## Laurie Leader - Re: 767 Congress - Plumbing Calcs.

**From:** Laurie Leader  
**To:** ara@2aarch.com  
**Date:** 3/3/2015 2:28 PM  
**Subject:** Re: 767 Congress - Plumbing Calcs.

Thanks for taking my call on Friday regarding the 767 Congress St. project. As requested, we have reviewed the code related plumbing calculations and have outlined them below for reference / discussion.

Sheet Title: SECOND (STREET) FLOOR PLAN

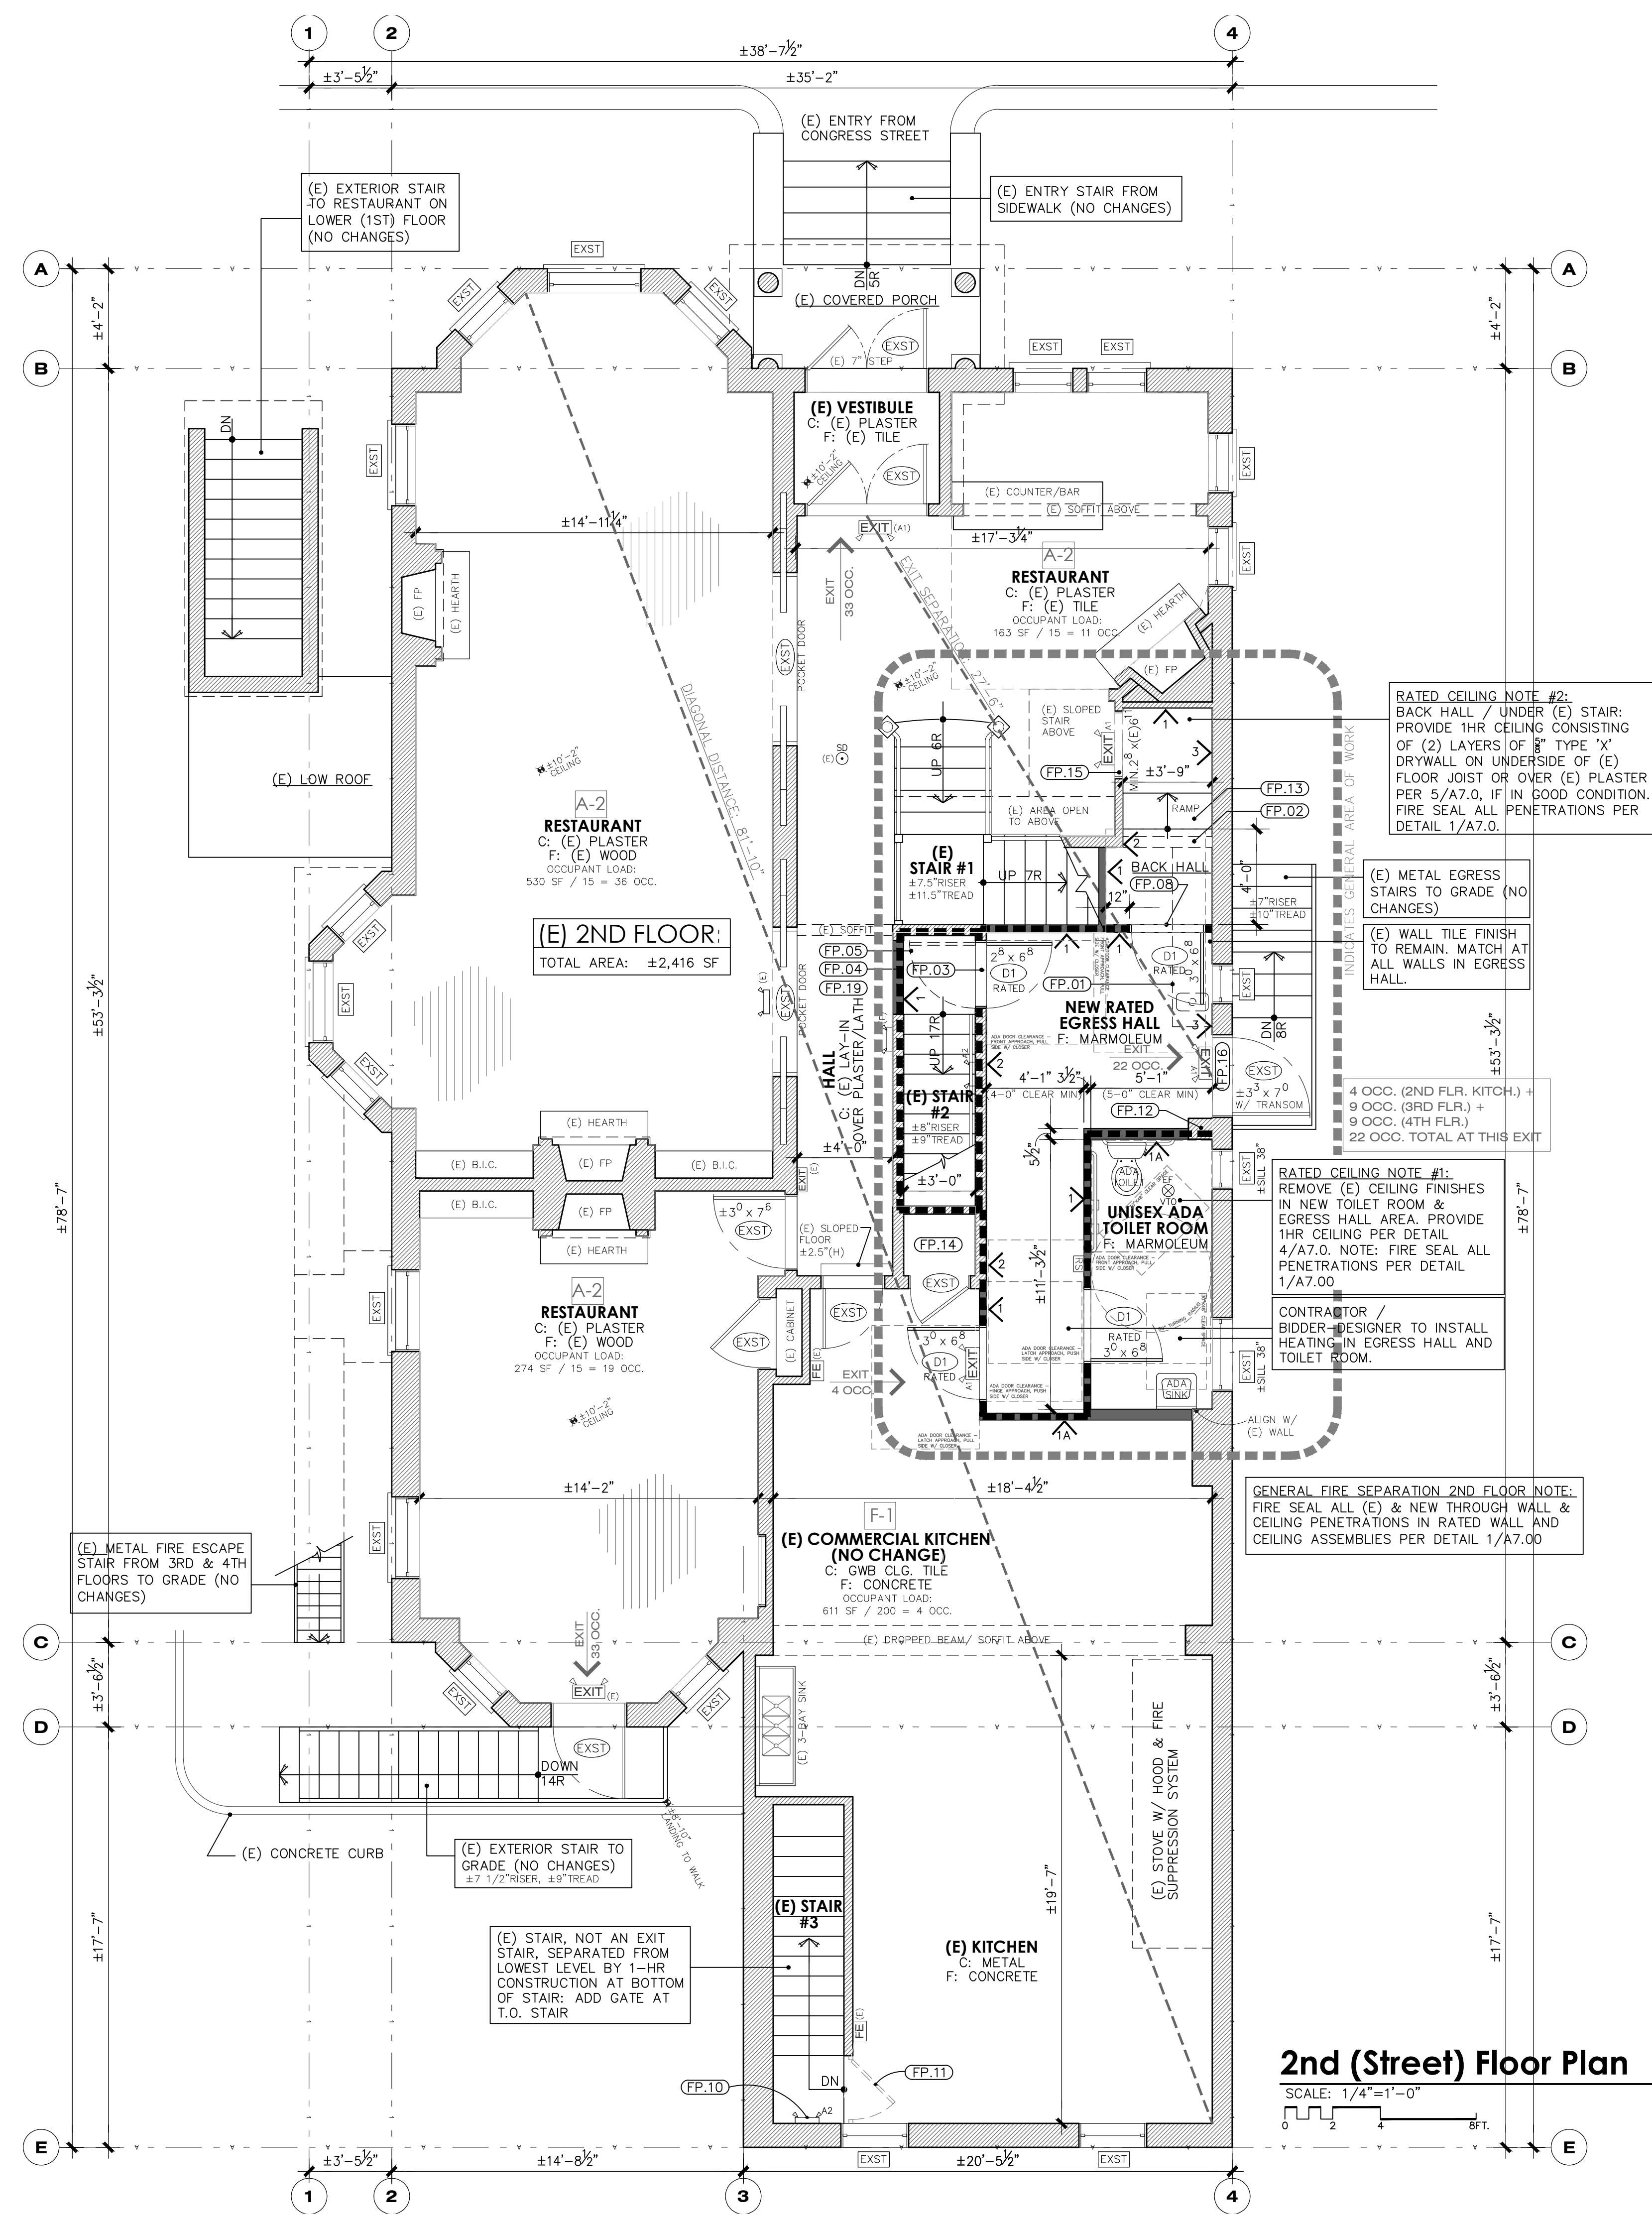
- Is the occupant load of 69 based upon the square footage of the entire floor area with calculations for staff (in the kitchen area) or is the calculation based on the seating area only?

You will definitely need an ADA compliant bathroom on the second floor. The question is, depending on the occupant load including staff, will you need one or two bathrooms on the second floor?

When you do move forward with the review, please show occupant load calculations with occupant loads broken down per area.
